Application no: 22/01815/DISC

Location: Land Approx 1 Mile From J9 East Of M40, Part Of M40 Through Chesterton Parish, Chesterton

Lead Local Flood Authority

Objection

Drawing title  
**Proposed Below Ground Drainage**  
Sheet 1 of 23

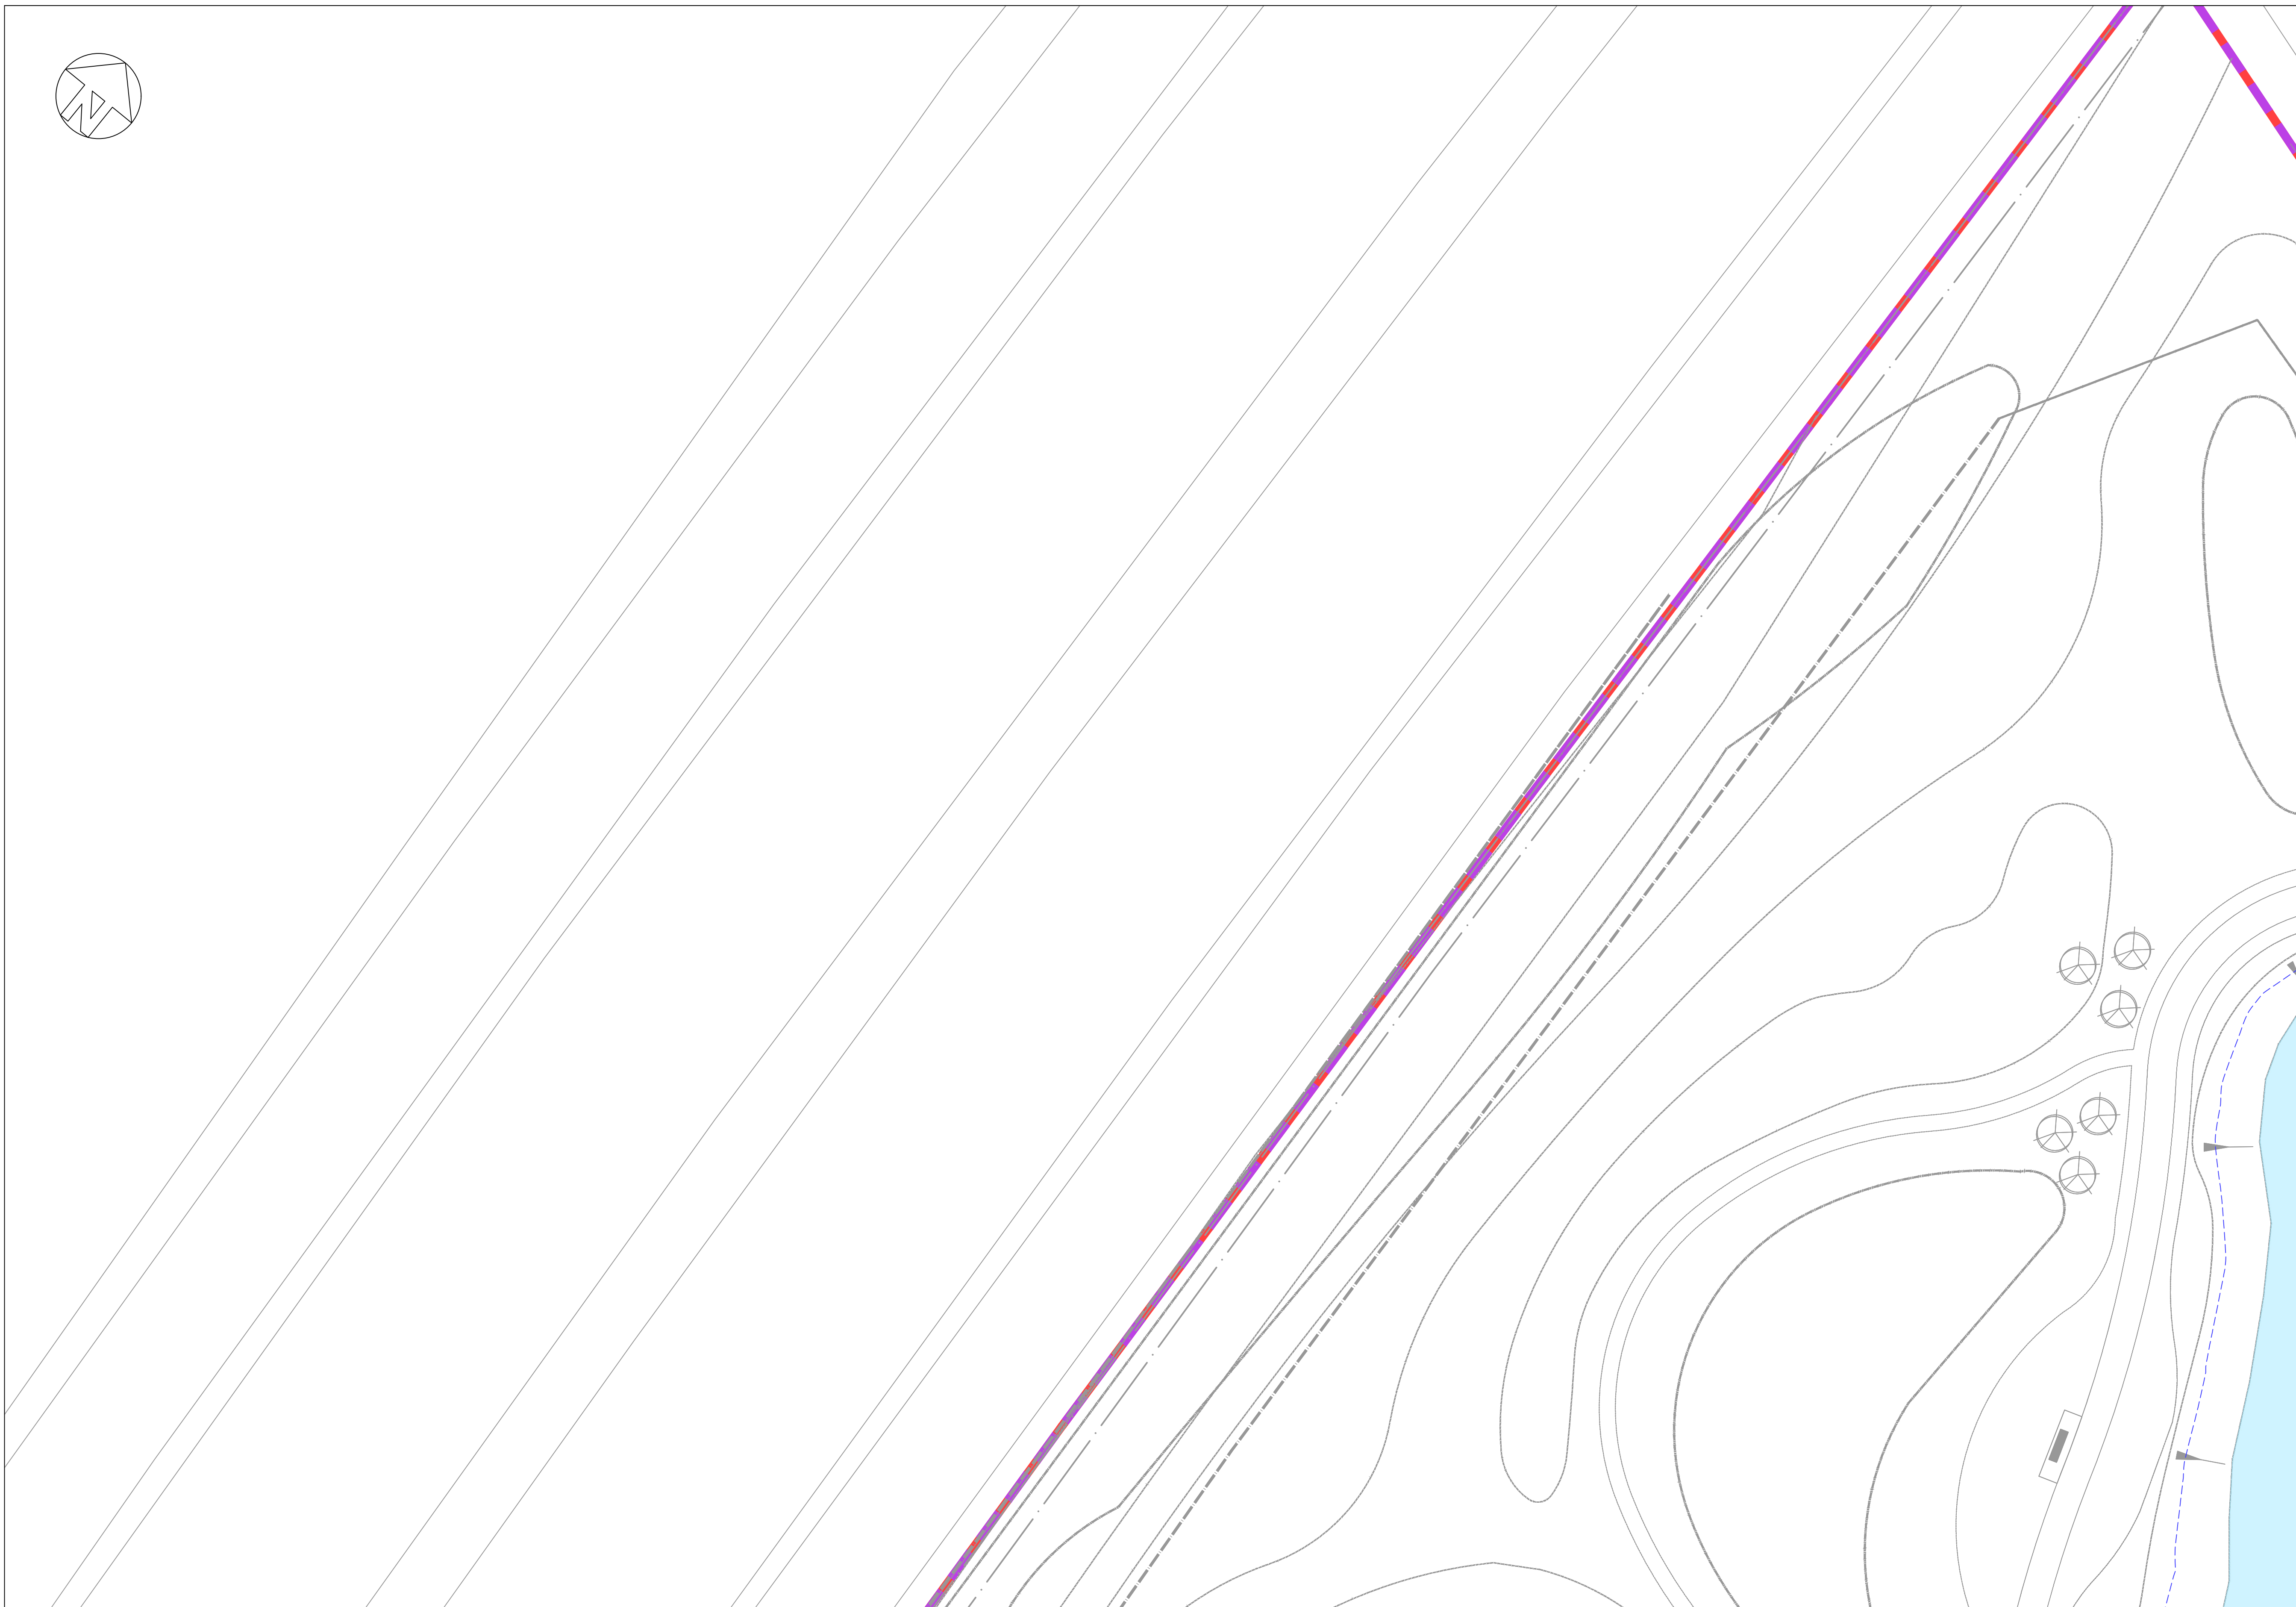
Provide surface water catchment plan, clearly showing the extent of the areas and stating the area. Ensure all SuDS features are labelled on the drainage strategy drawing and read in line with the calculations.

Provide pipe numbering on the drainage strategy drawing, which should read in line with the pipe numbering in the calculations.
